Office of
Environment
& Heritage

Your reference : MP09_0088
Our reference : DOC13/16944
Contact : Miles Boak 02 62297095

RE: Exhibition of Environmental Assessment for Concept Plan Approval – Mixed Use Subdivision, West Culburra (MP09_0088)

**MP09-0088 CONCEPT PLAN FOR A MIXED USE SUBDIVISION (LOT 61 DP755971, LOT 1
DP775061, LOT 7 DP880627 & LOT 8 DP825697) –
WEST CULBURRA - REALTY REALIZATIONS PTY LTD**

14 Attachment F – Typical Bioretention Swale, Basin and Wetland Design

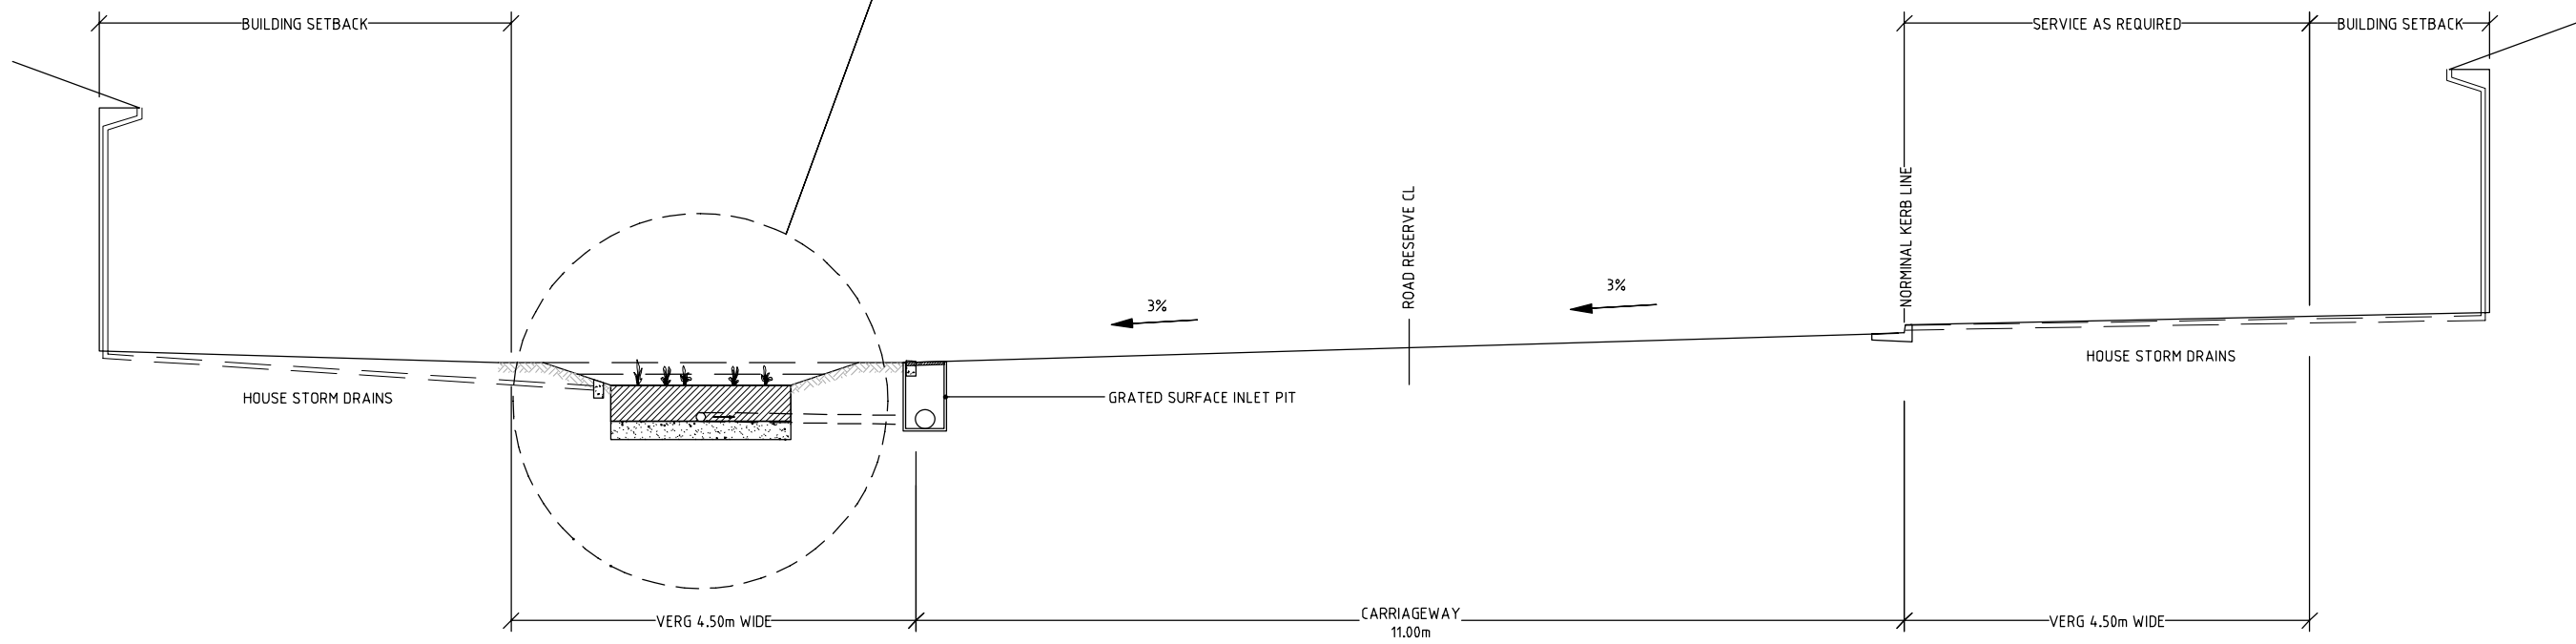
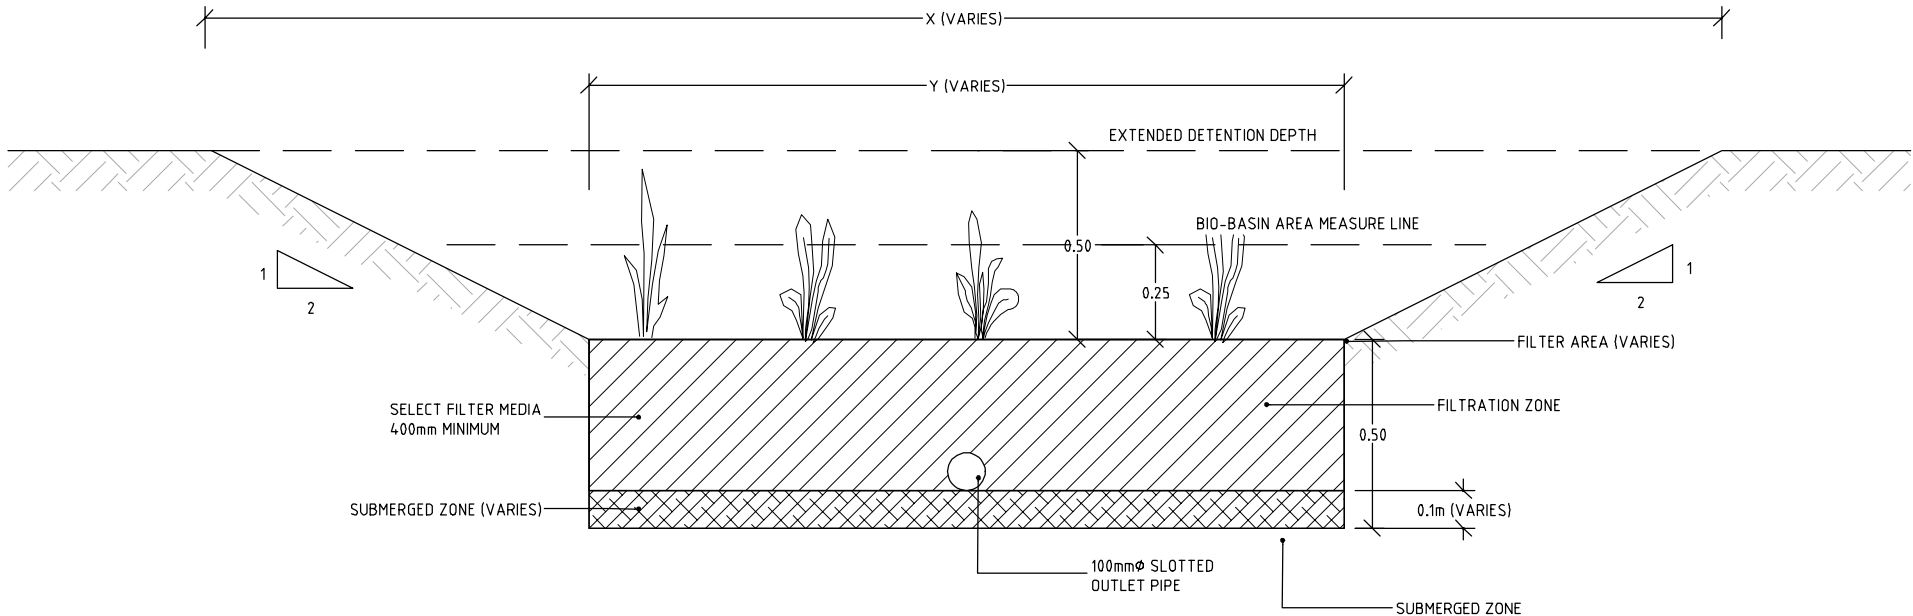
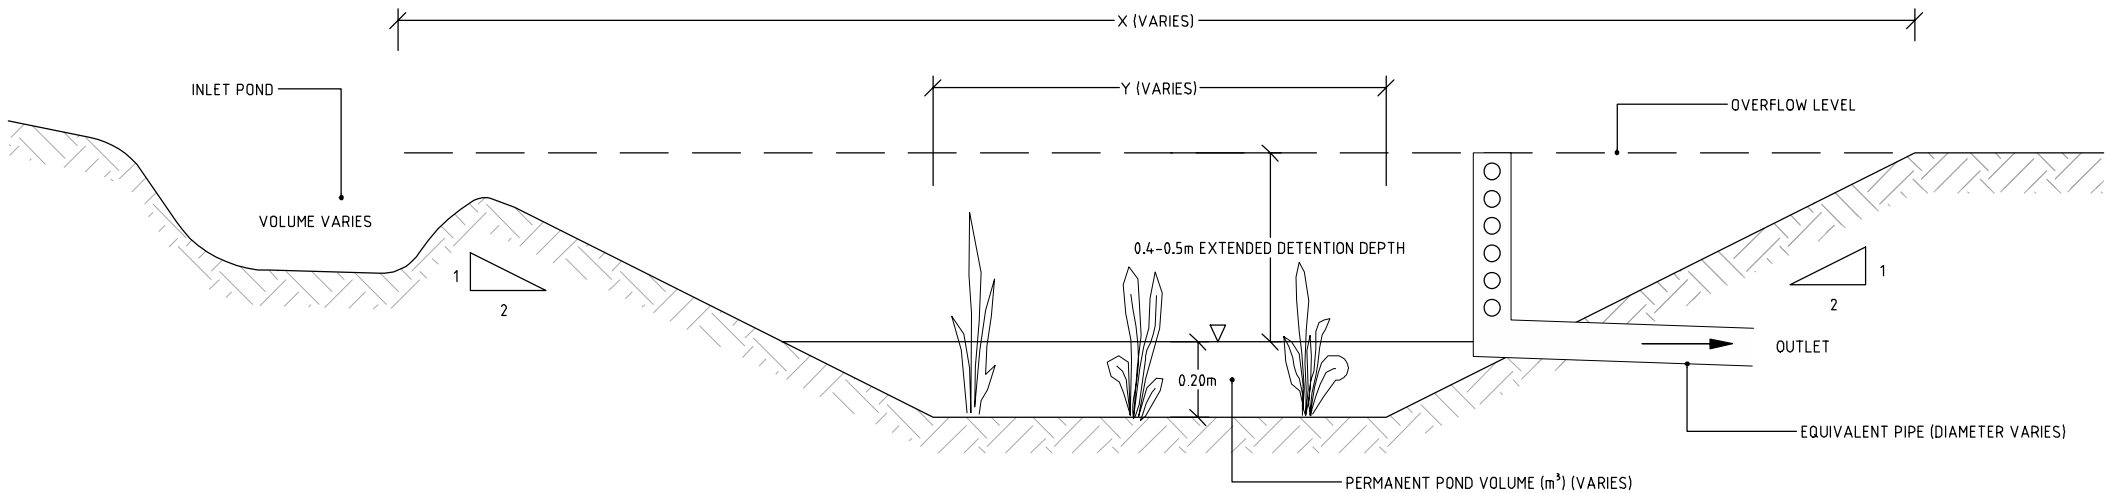
- The wetland design should also consider the Constructed Wetlands Manual (DLWC 1998) for design and planting purposes.
 - The bio-retention swales intended to go across the fall of the land need to be design at a maximum on a slope of less than 4%. Where these are designed to be on a slope of greater than 4%, scour treatment is to be provided and velocity calculations should be included

- 7(a) ZONE BOUNDARY
- GW1 GROUNDWATER MONITORING LOCATION
- WQ1 WATER QUALITY MONITORING LOCATION
- SF1 SHELLFISH MONITORING LOCATION
- PP1 PHOTO POINT LOCATION
- PROPOSED BASIN/WETLAND LOCATION (SIZE INDICATIVE ONLY)
- APPROX SEPP14 WETLAND EXTENT

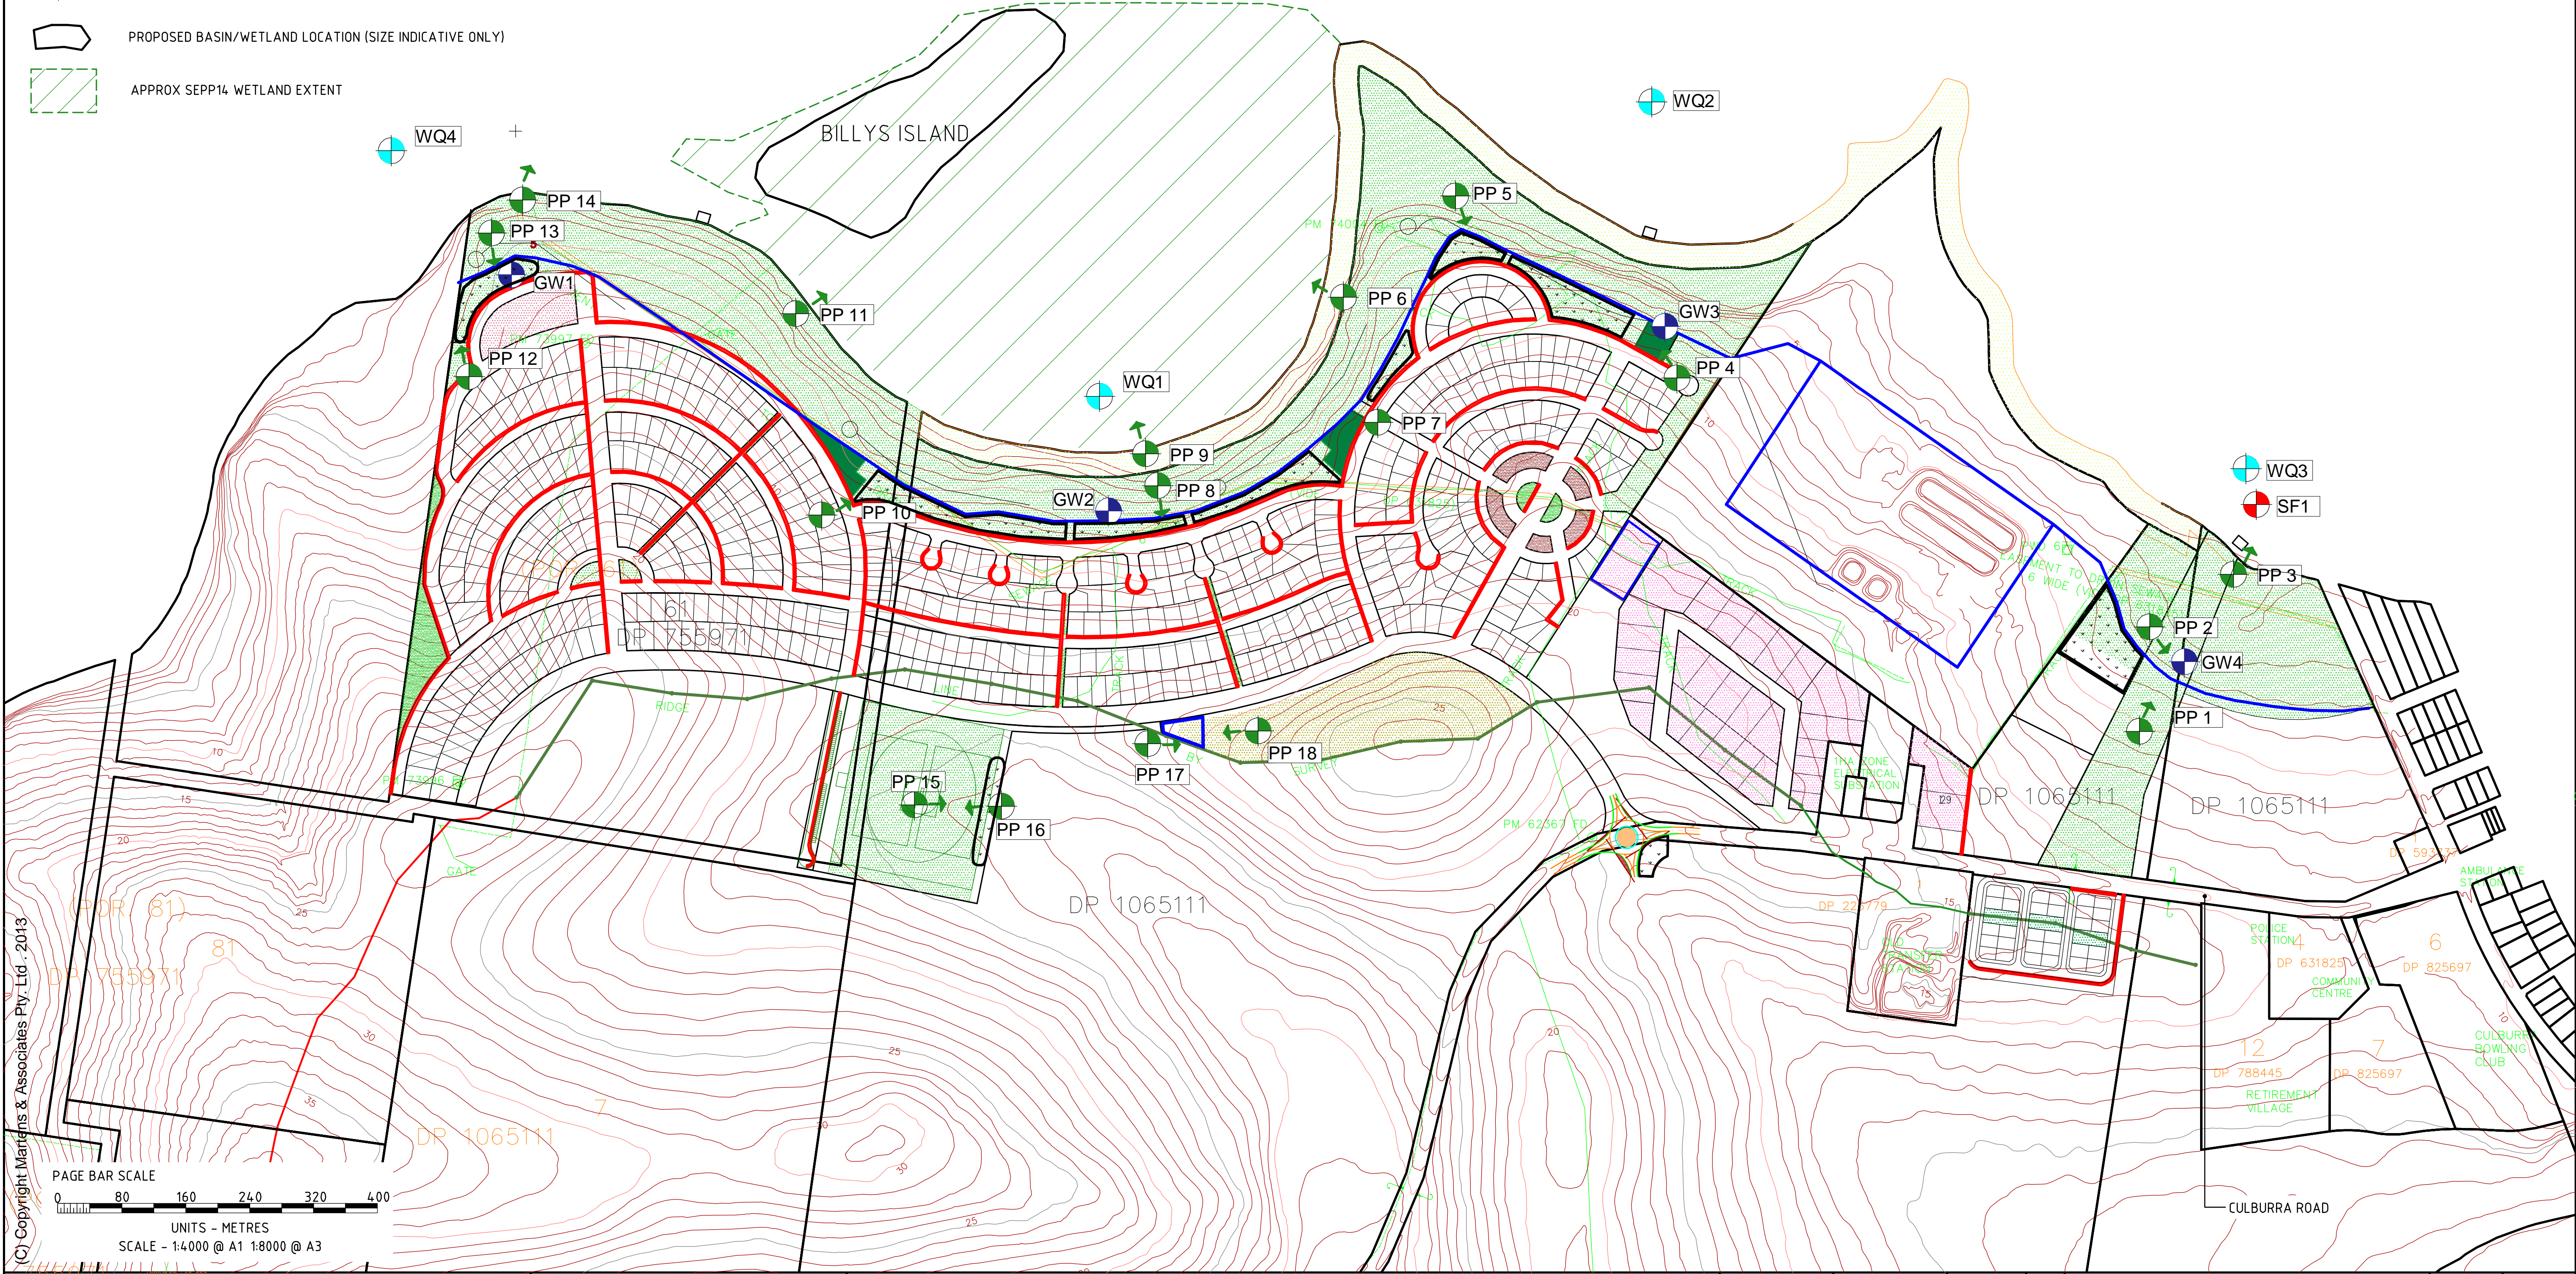
6. We consider that 3 Council sites (454, 455, 456 as depicted in Figure 2, pg 50) as well as a new 4th site to the immediate west of Cactus Pt should be monitored to adequately monitor any change in estuary health / water quality as a result of the development.
